Thames Water Utilities Limited

Riverside Energy Park Examination – EN010093

Submission of Comments on behalf of Interested Party Thames Water Utilities Limited

**Submitted at Deadline 7
3 September 2019**

Plate 9.1: Design Principle of the Stepped Roof

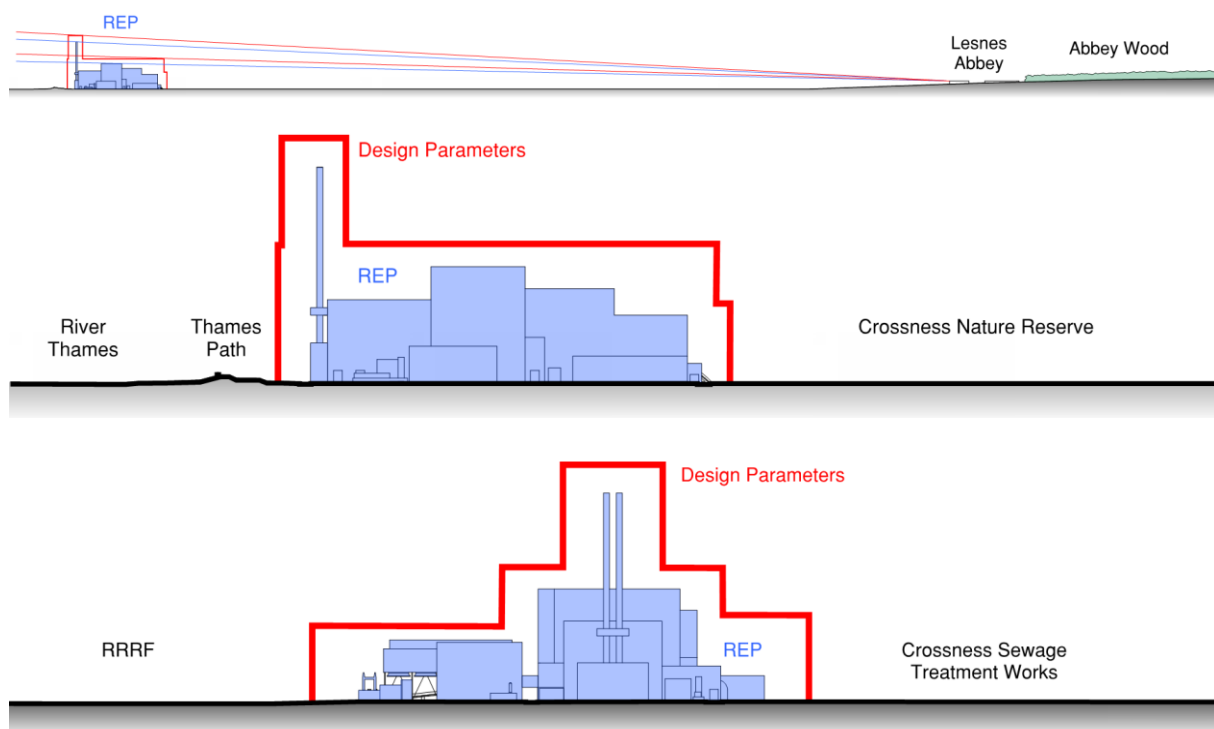
- 3.14.1 In response to paragraphs 1.3.5 – 1.3.9 of the Applicant’s Response to TWUL’s Deadline 4 submission [REP4-038 and REP4-039], TWUL’s position remains the same regarding its preference for the curved roof design of the Project.

Predicted Hourly Average NO₂ Concentration

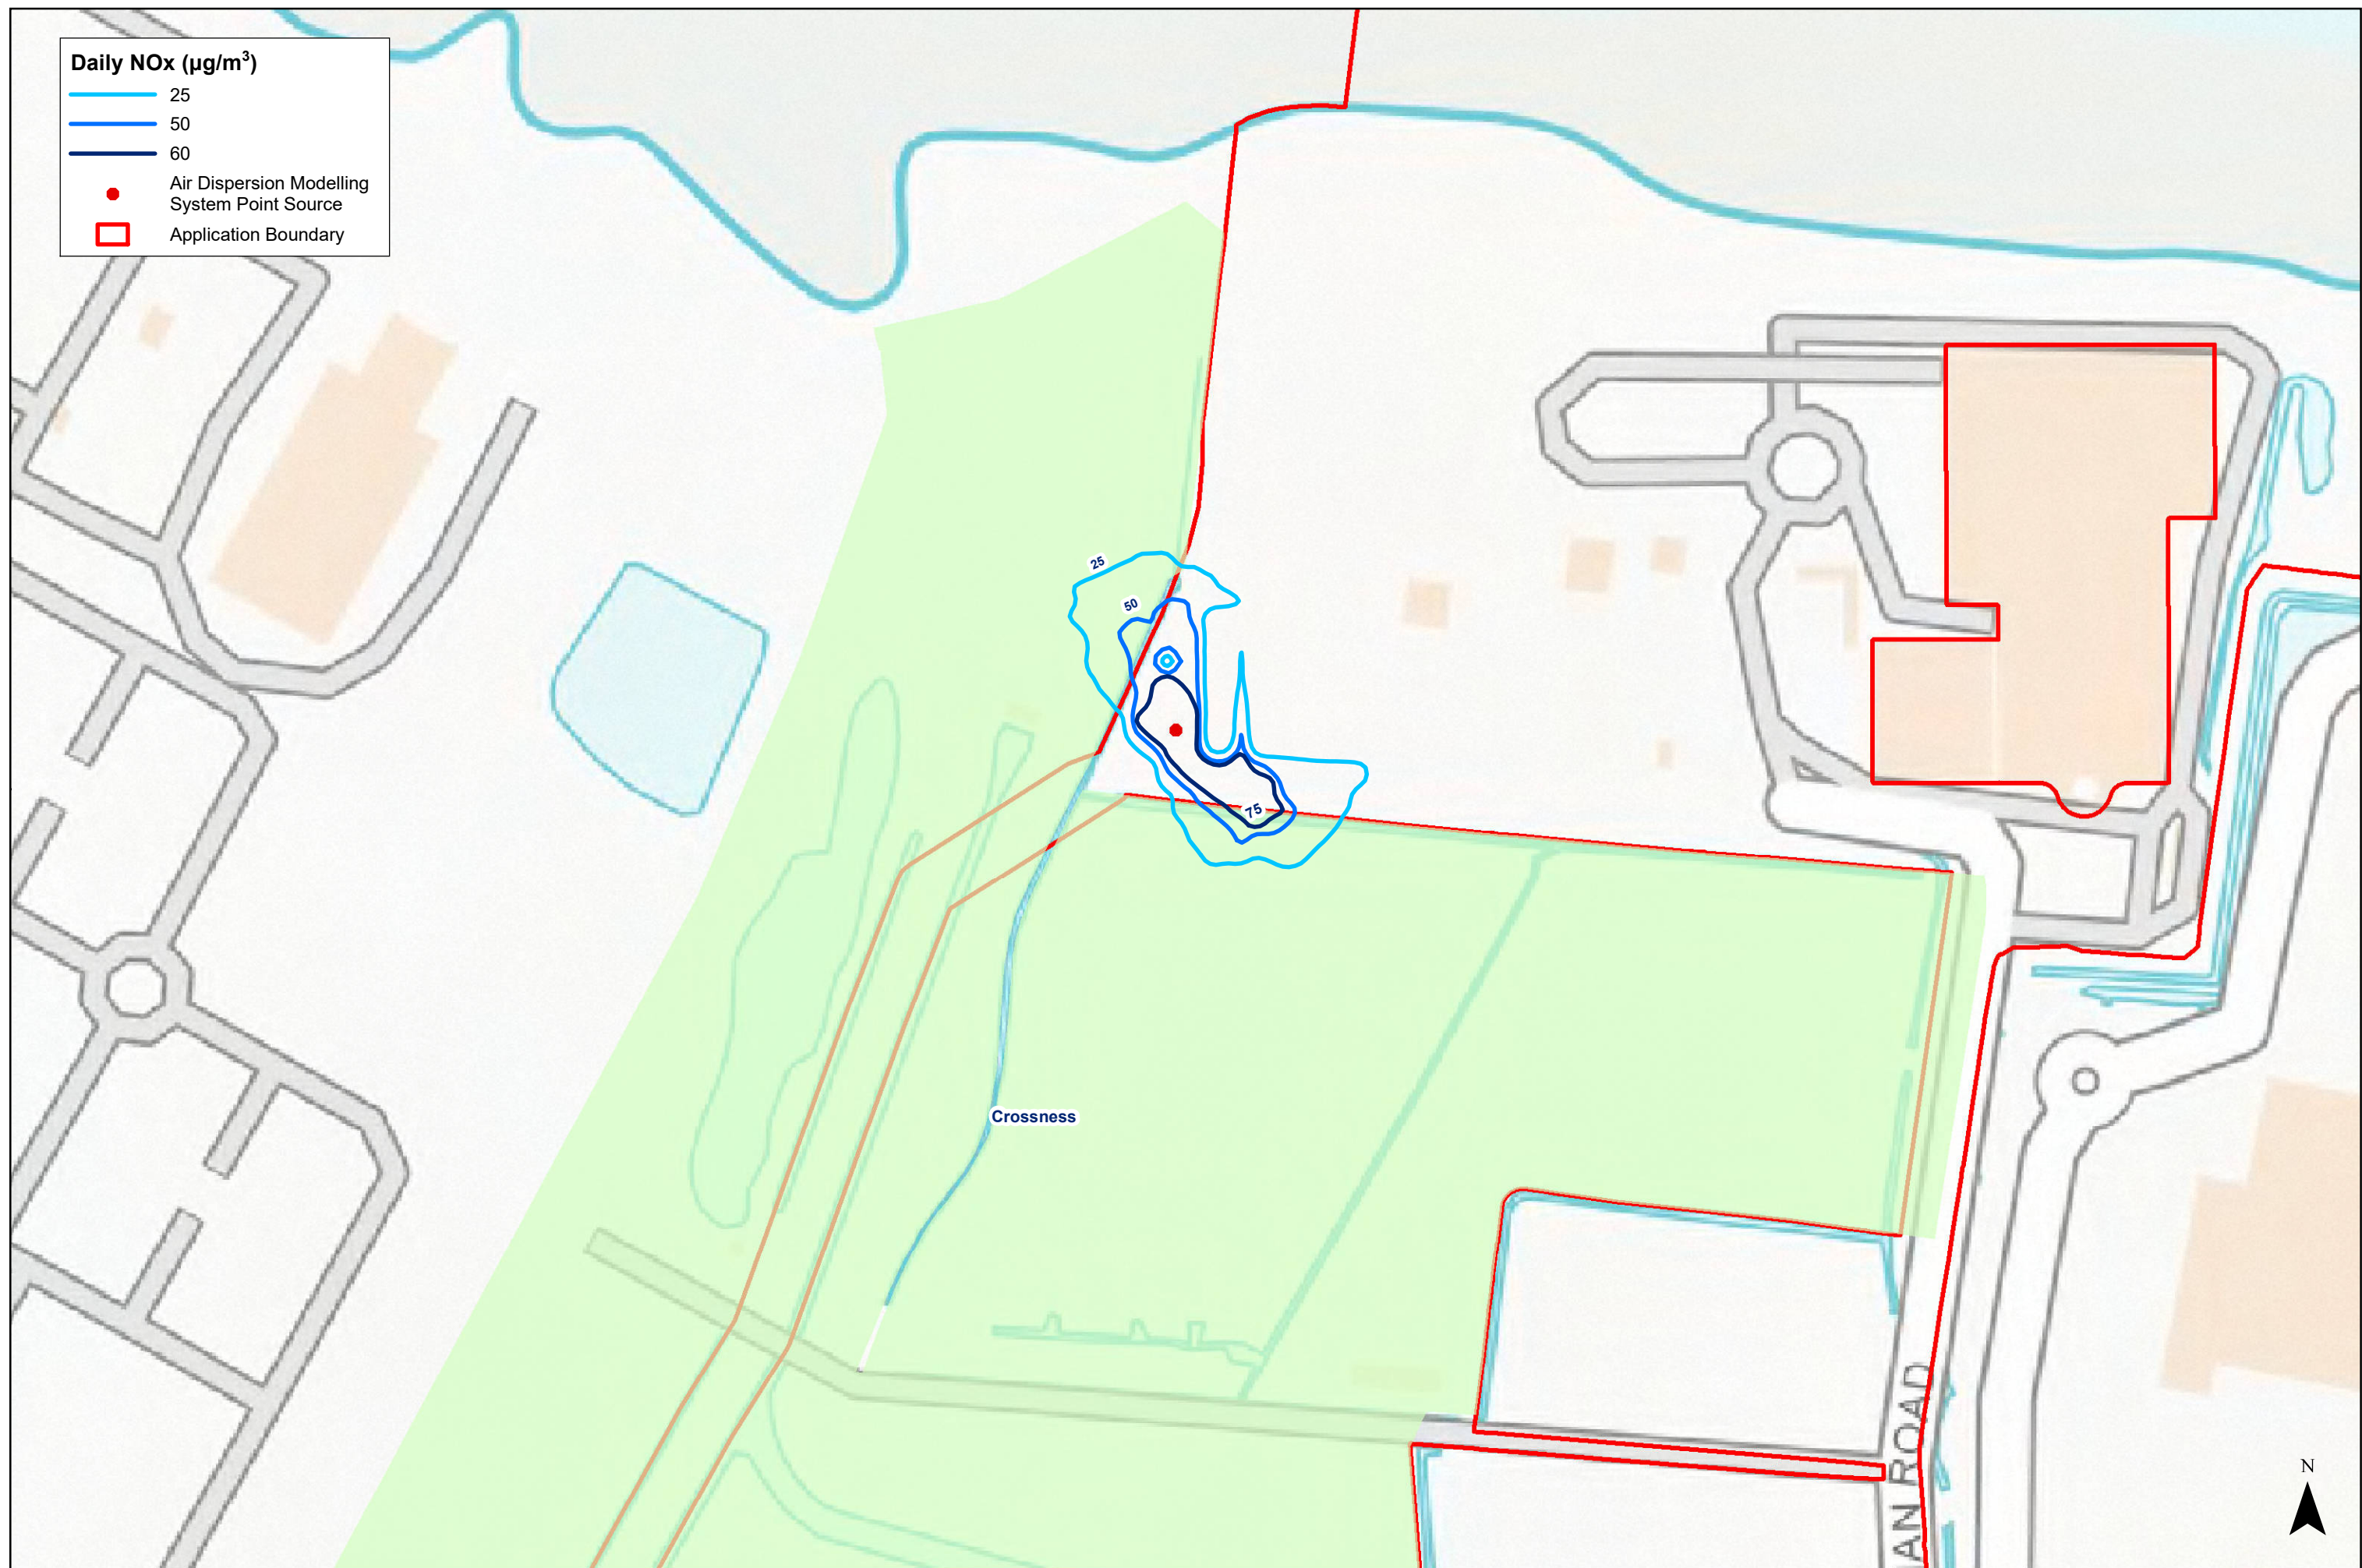
- 3.13.2.1 the Project and Data Centre buildings detract from the natural beauty of the marshland landscape;
- 3.13.2.2 NOx emissions will alter the adjacent vegetation structure;
- 3.13.2.3 buildings shade out the adjacent ditches and flora; and
- 3.13.2.4 three to five years of construction disturbance will remove breeding bird species.
